Notice of Exhibition of application for Sydney Metro West Concept and Stage 1 Application - SSI project SSI 10038

As delegate of the Heritage Council of NSW, I provide the following comments:

Tim Smith, OAM
Director Operations
Heritage NSW
Department of Premier and Cabinet
As Delegate of the Heritage Council of NSW
3 July 2020

Figure 12-2: Parramatta metro station construction site – Heritage items and conservation areas

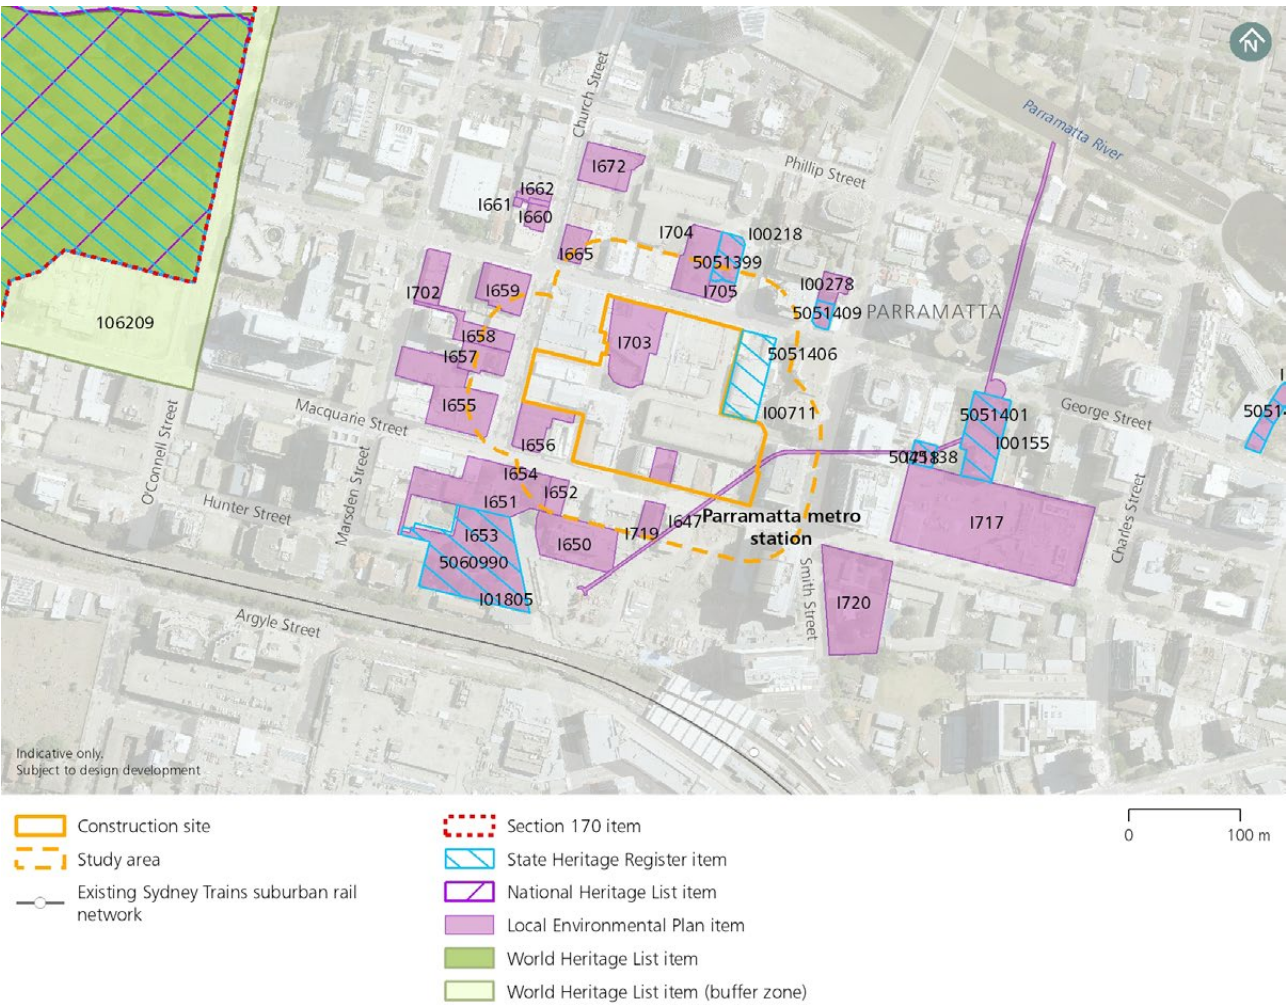
HNSW notes that the Roxy is outside the Construction zone for the Parramatta Metro Station but it would be immediately adjacent this zone. Tech Paper 3 (Table 71, p241) advises vibration and settlement are anticipated to be the main impacts from the project along with a change in the immediate setting to the item. HNSW recommends the setting could be improved by confirmed height limitations for the metro station in direct proximity to the Roxy.

The project anticipates there will be a level of settlement from the project at 25mm with a Risk level of 2 (involving superficial damage). Further details of how the project proposes to manage this impact to the Roxy is requested at RTS stage. This may require commitments for earlier condition assessment, monitoring during the project, and commitments about rectification at the end of the program.

Within the Metro station boundary, the remains of the Convict Barrel Drain (1820s) locally listed item survives. The proposal is likely to remove any surviving sections of this drain in the construction zone. This item has been known since the 1980s and is identified in the Parramatta LEP. However, its successive removal has led to less of this surviving significant structure remaining intact. Its management should aim to avoid the fragment surviving in Macquarie Lane and within the study area. Recently approved archaeological investigation is proposed by Casey and Lowe Pty Ltd and is relevant to part of the Metro study area. This aims to avoid the item, where found. HNSW therefore requests further advice on how the project would manage the retained and conserved in-situ remains of the Barrel drain for the Metro.

Figure 12-8: The Bays Station construction site – Heritage items and conservation areas

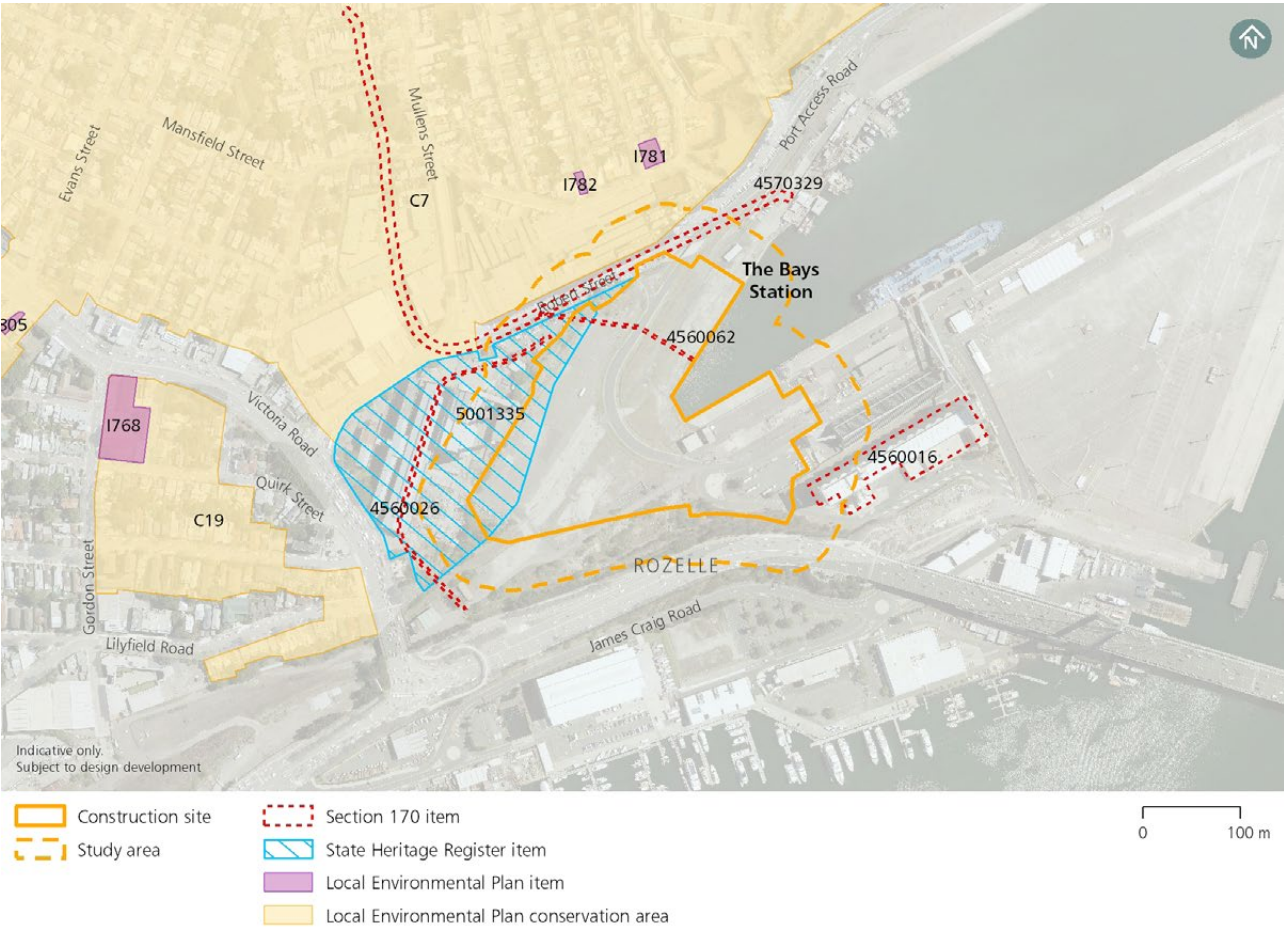
Curtilage encroachment: The current curtilage was established to retain the visibility to and prominence of the WBPS as a harbourside landmark. The curtilage contributes to retaining its impressive scale and setting. The Conservation Management Plan (CMP) notes that WBPS should not be substantially obscured by any development on nearby sites. The project would require the construction zone to extend into the WBPS curtilage, which would adversely impact the setting and context of the WBPS and potentially diminish its overall massing, configuration and visibility. Further, the relocation of the Port Access Road into the curtilage will change the interpretation and understanding of the item. The project does not propose to mitigate this change.

*Heritage NSW **recommends** that the project should consider reducing the construction zone within the SHR curtilage, in particular along the construction boundary adjacent to the Boiler House.*

Acoustic Sheds: Two (2) 15m high acoustic sheds will be constructed to the east of the WBPS for the duration of the construction period. Due to their proposed height and placement (particularly alongside the Boiler House) will have an adverse visual impact on an important identified view of the WBPS by diminishing its impressive scale. It is unclear if both sheds will be constructed at the same time. Consideration should be given to reducing the height of the sheds and their placement should be carefully positioned to ensure visual impacts to the setting of the WBPS are minimised.

Demolition: The document notes that several non-significant structures within the WBPS curtilage would be demolished. It is unclear which items and how significant these structures are. The Heritage Act 1977 sets strict requirements for demolition of items within an SHR curtilage which is a controlled activity. Further clarification should be provided to confirm the significance and location of these structures and the justification for the demolition. The Figures in Tech Paper 3 do not clearly show the location of the WBPS related to the Bays Metro station construction layout, this should be rectified to include the SHR curtilage and designated a heritage item (Ref Artefact 2020, Figure 19, p39).

The Archaeological potential identified within the Bays Metro station is focused on the White Bay Hotel which was constructed in the 1850s/1860s. This building was demolished in 2010 following a fire which damaged the building. HNSW is however unclear why, if the building was considered not sufficiently significant to be retained although the correlation between this hotel and the White Bay Power station is noted. It is however unclear how its archaeological resource would now warrant detailed investigation and management by the project or what new information would be revealed. HNSW requests that the proponent provide more evidence to justify the archaeological approach being proposed.
